Statement of Response to An Bord Pleanála Opinion in respect of the proposed **Creamfields SHD, Cork**

Prepared in February 2022 on behalf of

Watfore Limited

Client	Watfore Limited
Project Title	Creamfields SHD
Job No.	CON20051
Document Title	Statement of Response to ABP Opinion
Number of Pages	30

1 Contextual Elevation - East  
1:500

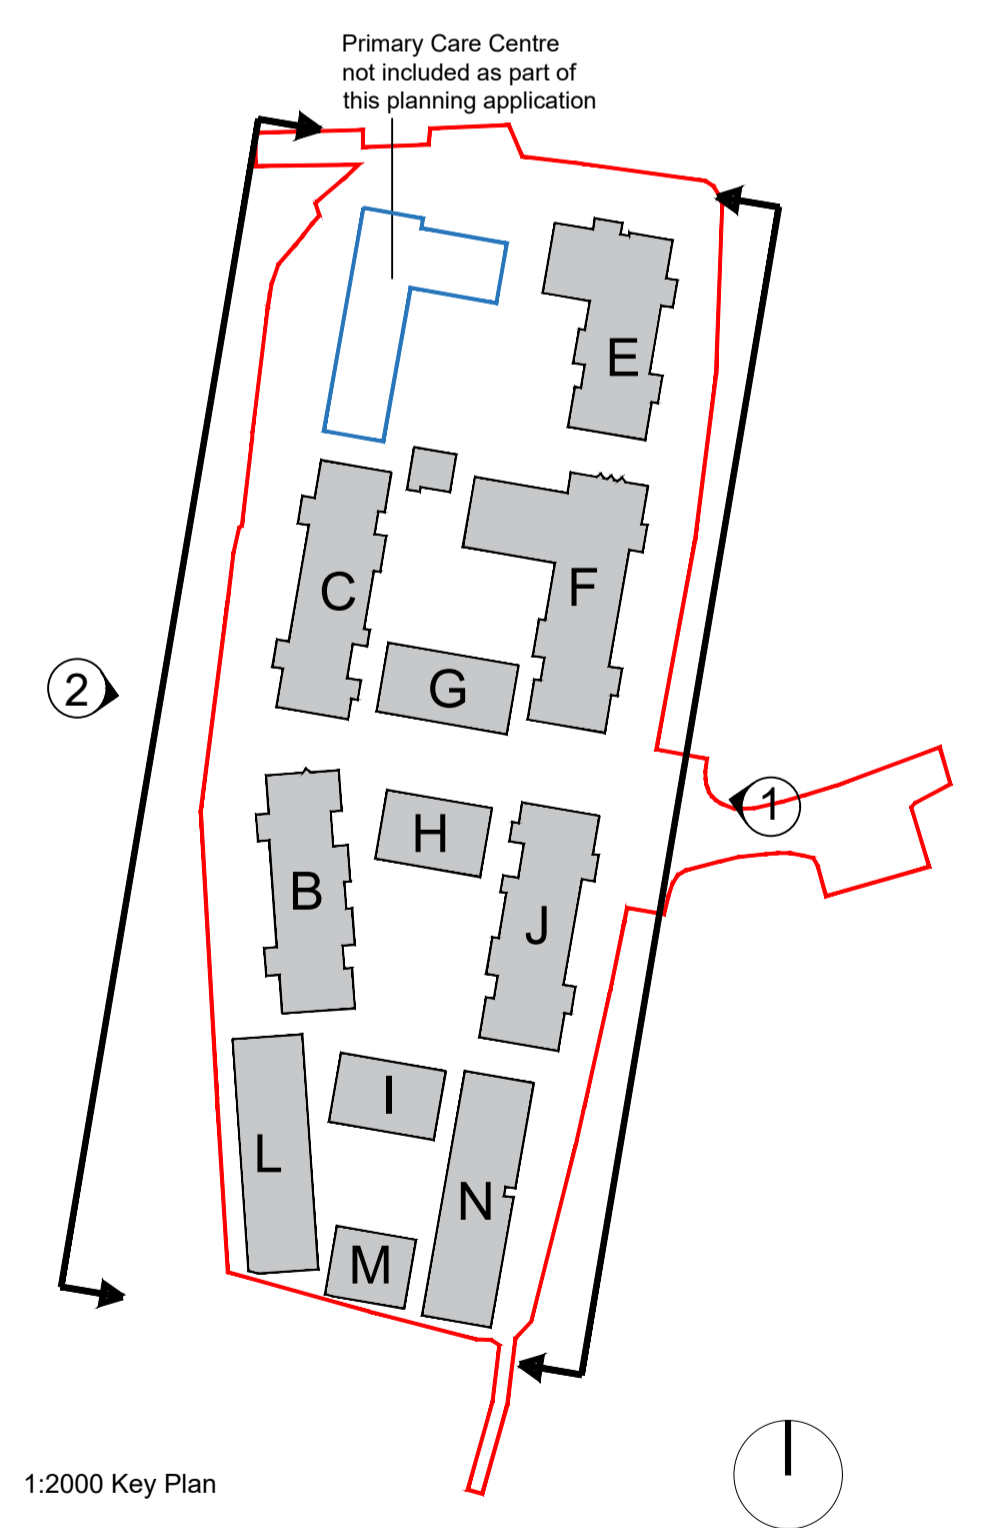
Further justification for the height strategy, integration with the wider area and density, specifically how transition occurs in terms of design, presentation, quality community and place making. A key issue at this location is the existing environment and specifically how transition occurs between the existing established development and the proposed development cognisance being had that this development will form a catalyst for future development on surrounding lands.

- 1. An updated Architectural Design Statement. The statement should include a justification for the proposed development, having regard to, inter alia, urban design considerations, visual impacts, site context, the locational attributes of the area, linkages through the site, pedestrian connections and national and local planning policy. The statement should specifically address finishes of the blocks, the design relationship between the individual blocks within the site, the relationship with adjoining development and the interface along the site boundaries. The statement should be supported by contextual plans and contiguous elevations and sections.

- 2.3.7 The transition that occurs between the existing, surrounding established development and the proposed development consists of a stepping up of scale along the Kinsale Road from 2-storey retail to a 15-storey landmark building in two storey increments.

- 2.3.8 The transition in scale along the Tramore Road moves west to east from a large-scale major distribution warehouse, stepping up to a 7-storey Primary Care Centre (the subject of a separate planning application
